# CITY OF ALBUQUERQUE

September 26, 2023

**Re: Take 5 Oil Change**  
**2151 Gibson Blvd. SE**  
**Traffic Circulation Layout**  
Engineer's Stamp 08-28-23 (M15-D021E)

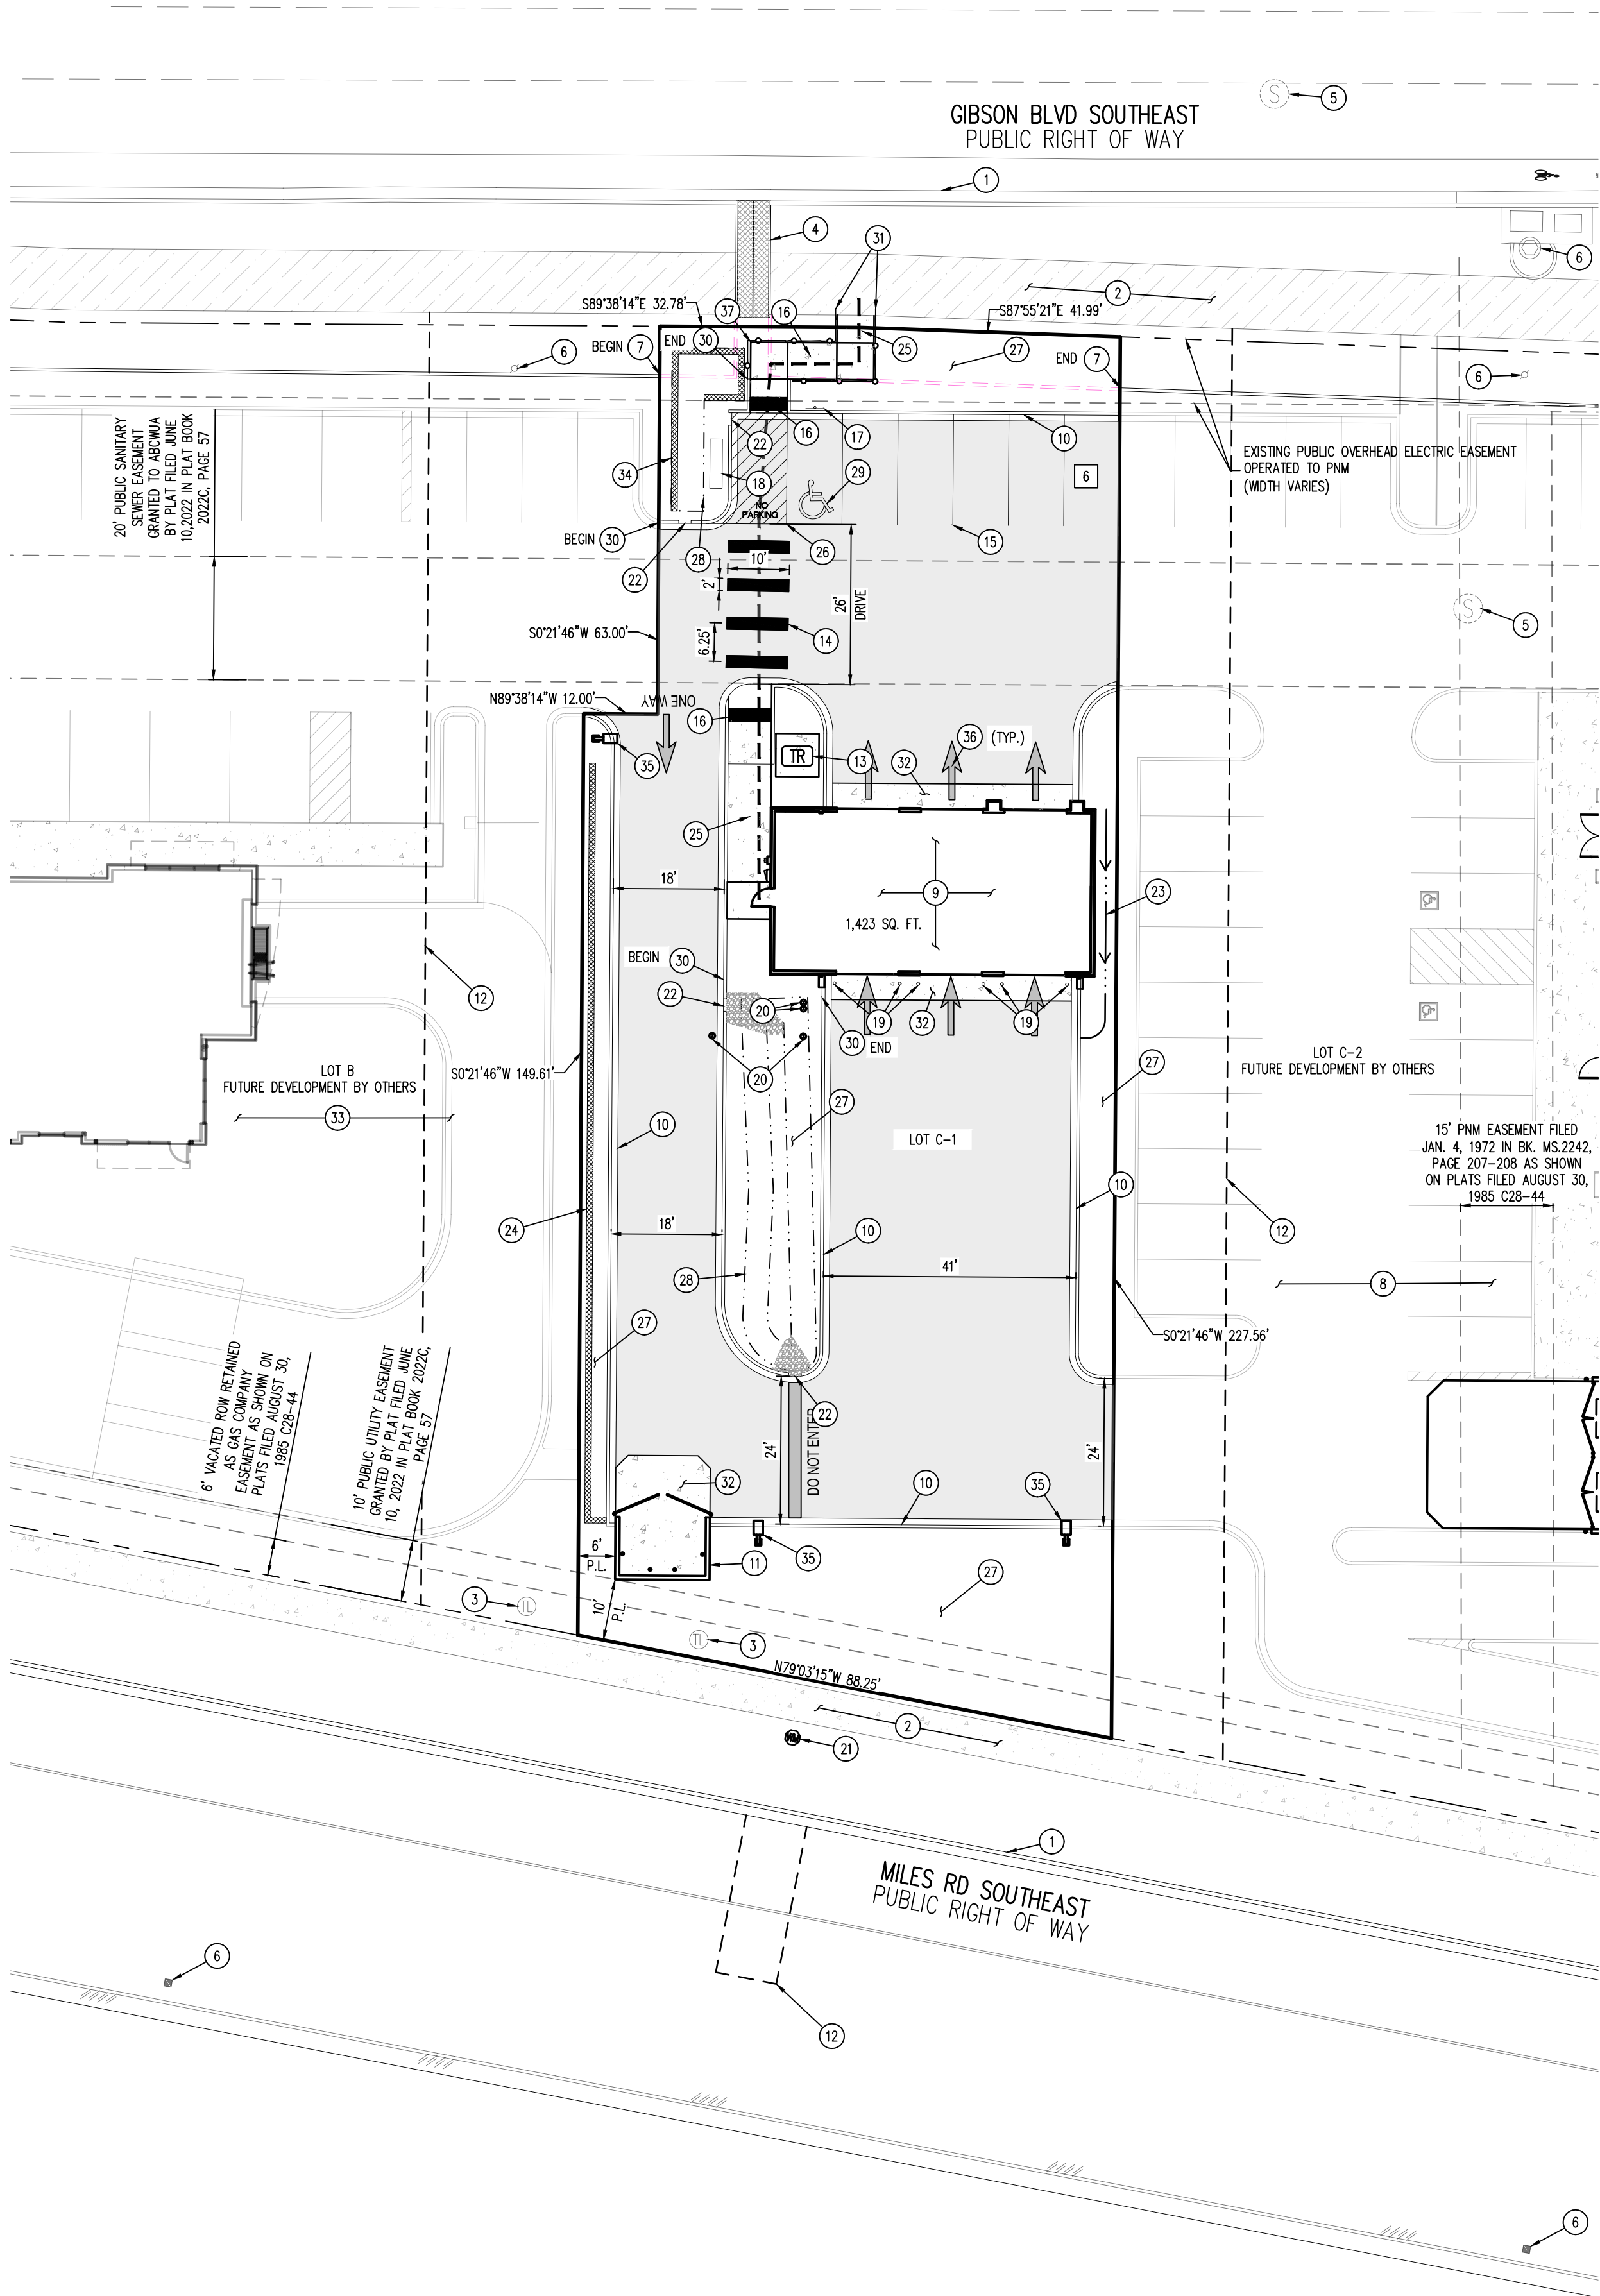
1. Identify all existing access easements and rights of way width dimensions.
2. Identify the right of way width, medians, curb cuts, and street widths on Gibson Blvd. and Miles Rd.

7. Per the IDO, a 6 ft. wide ADA accessible pedestrian pathway is required from the public sidewalk to the building entrances. Please clearly show this pathway and provide details.

8. Per DPM, a 6 ft. wide ADA accessible pedestrian pathway is required from the ADA parking stall access aisles to the building entrances. Please clearly show this pathway and provide details.

9. ADA accessible pedestrian pathway should not be placed behind parking space or adjacent to a vehicular way. Vehicle and pedestrian/wheel chair conflicts should be avoided as much as possible.

11. Please provide a copy of Fire Marshal approval.
12. All one-way drives shall have "One Way" and "Do Not Enter" signage and pavement markings. Please show detail and location of posted signs and striping.

H:\00000001 - Gibson & Valencio\03-CD\000001 - C1-2 TRUCK TURN.dwg - 08/15/2025

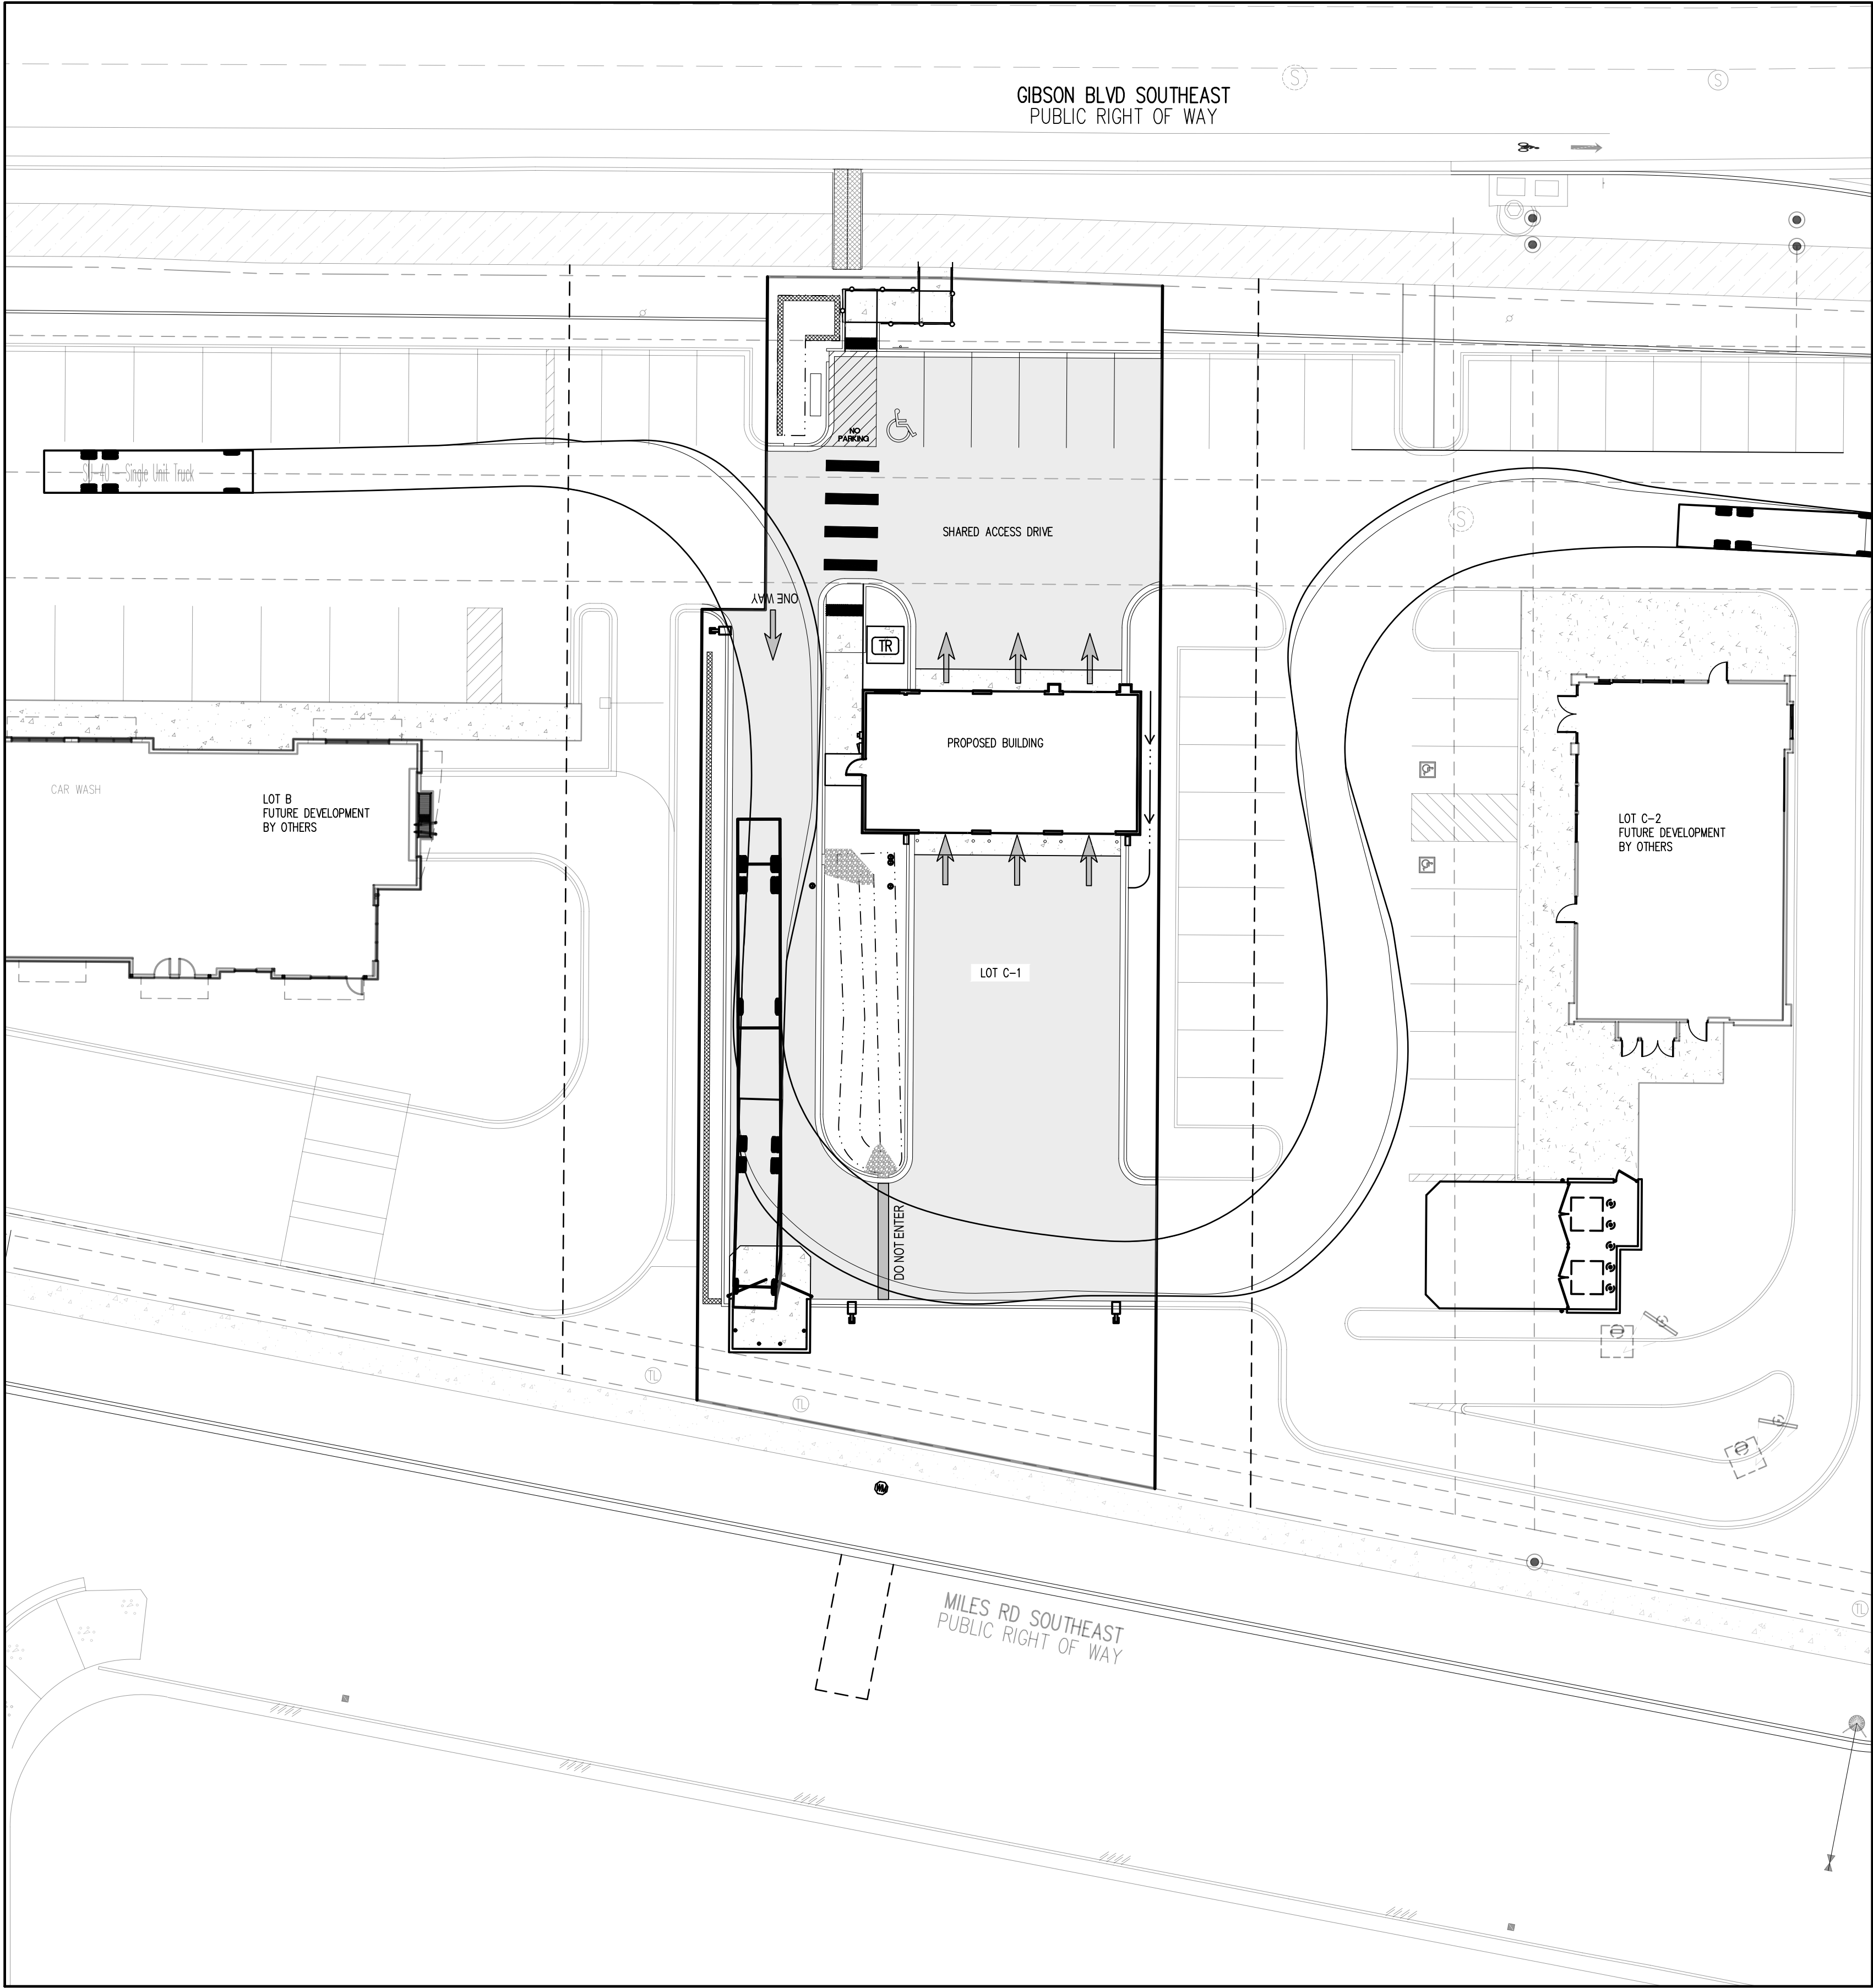
10. Refuse vehicle maneuvering shall be contained on-site. The refuse vehicle shall not back into the public right of way.; provide a copy of refuse approval.
